Please ask for: Ms Iqraa Malik
Email: iqraa.malik@terraquest.co.uk
Telephone: 0121 234 1390
Our Ref: AW/383/21/HH
Your Ref:
Date: 17th November 2021

Application for Planning Permission for Works or Extension to a Dwelling

Development: Retrospective application for erection of outbuildings in rear following demolition of existing.
Location: 22 Gossamer Lane Aldwick PO21 3BY

Proposed Site & Roof Plan

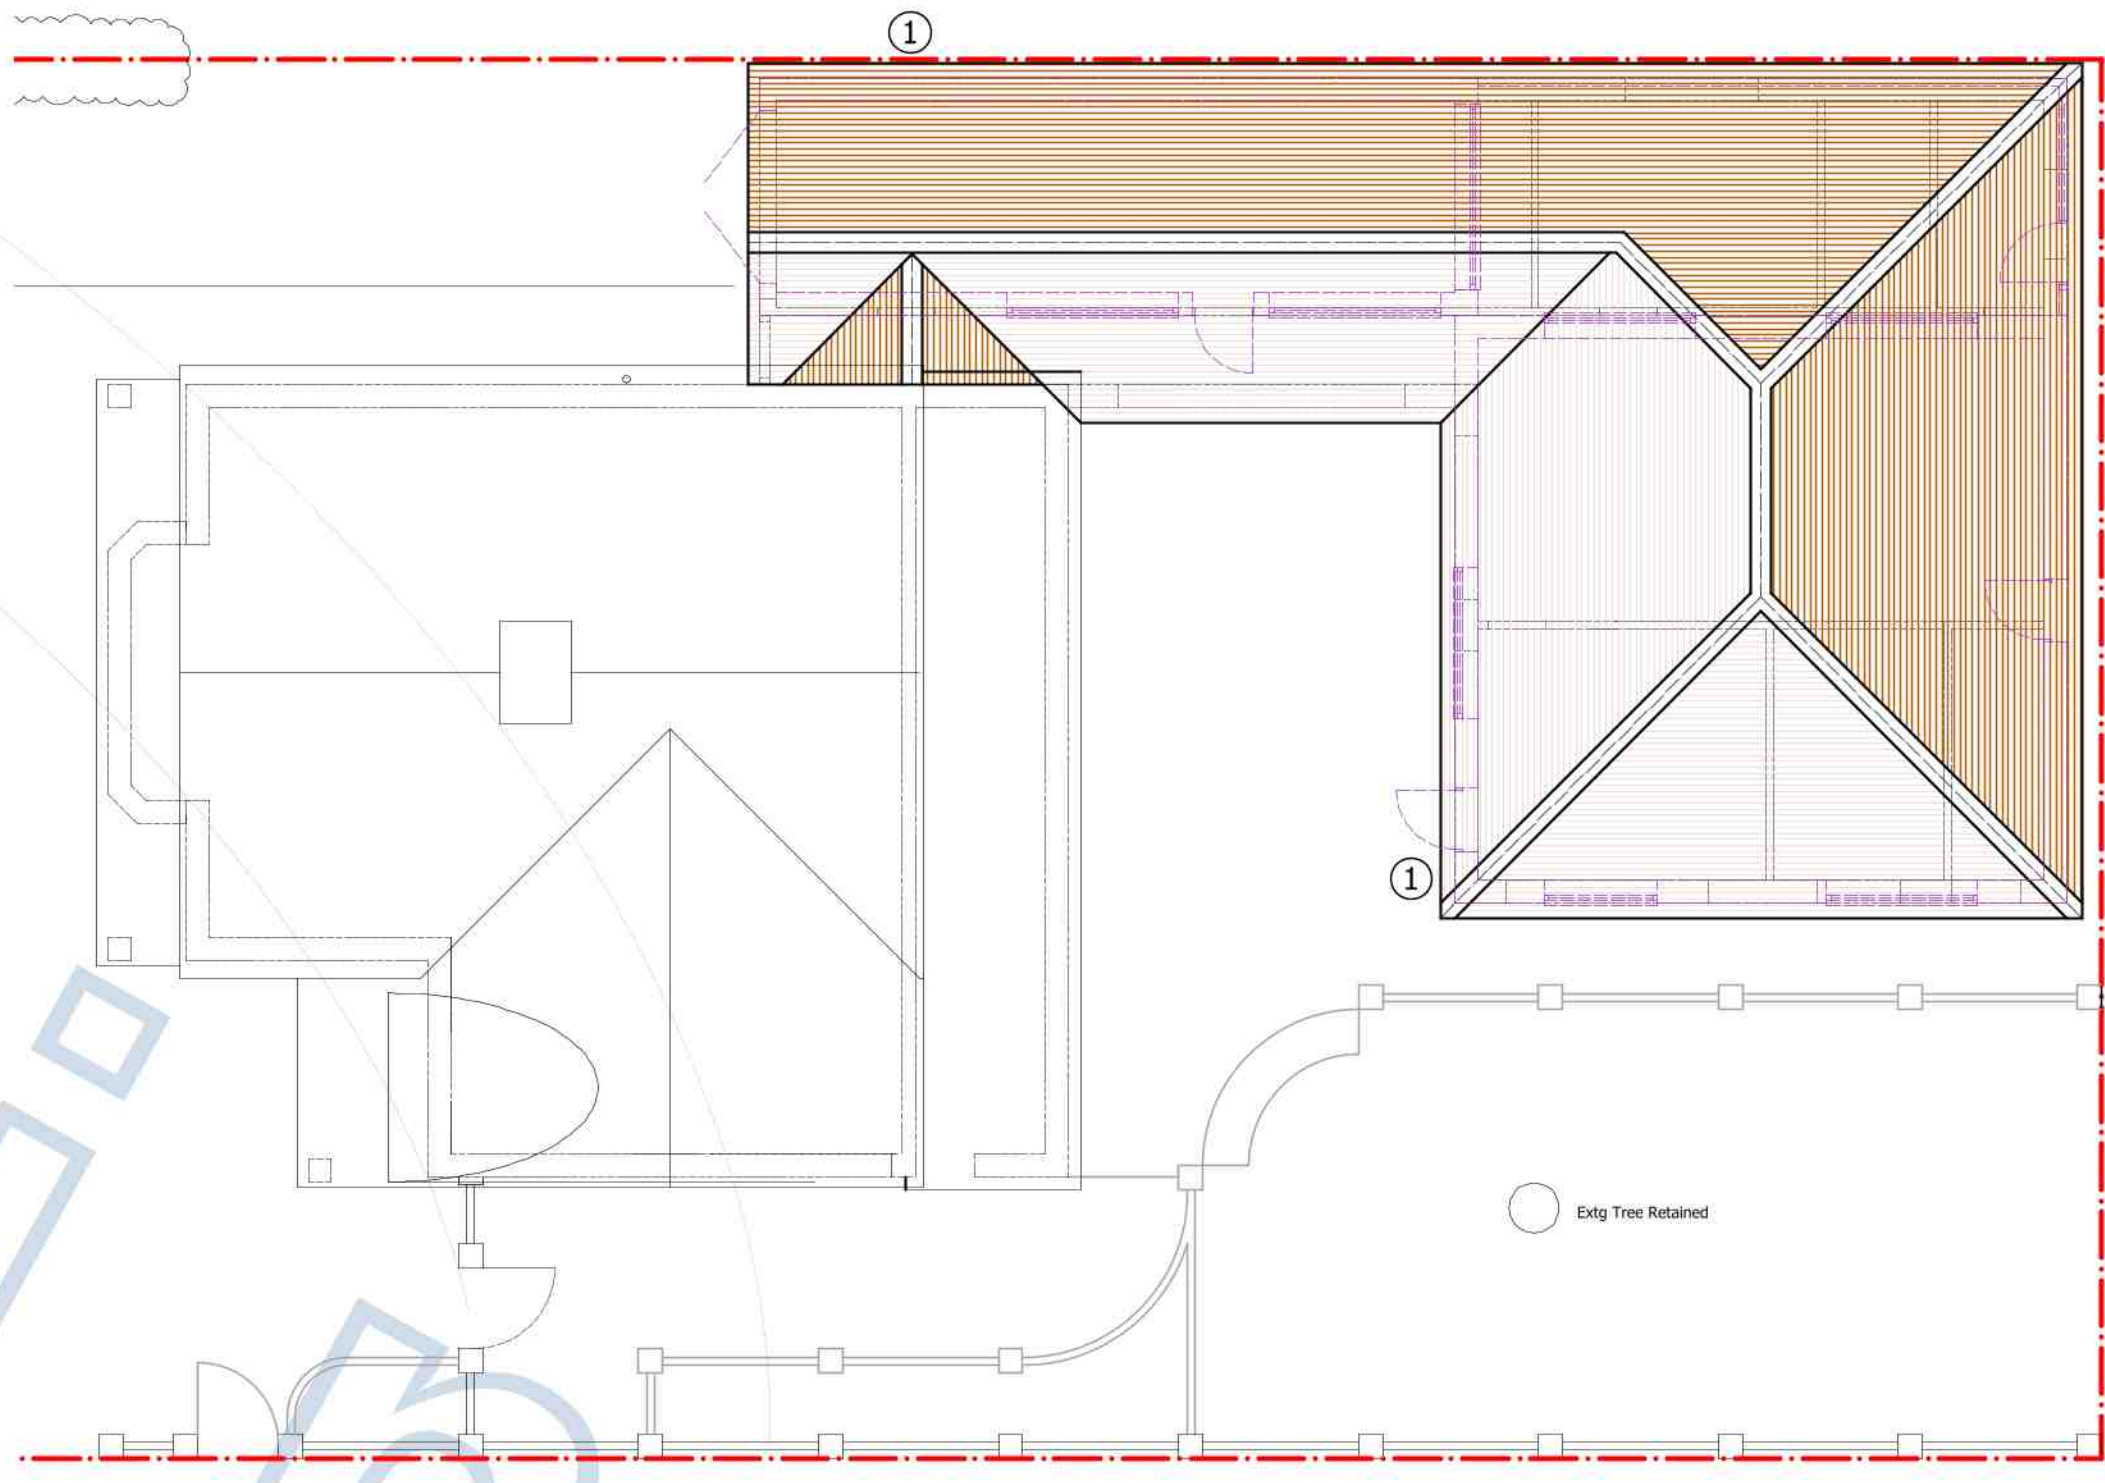
Block Plan

You are required to have dimensions from the proposed extension(s) to all site boundaries. Please amend.
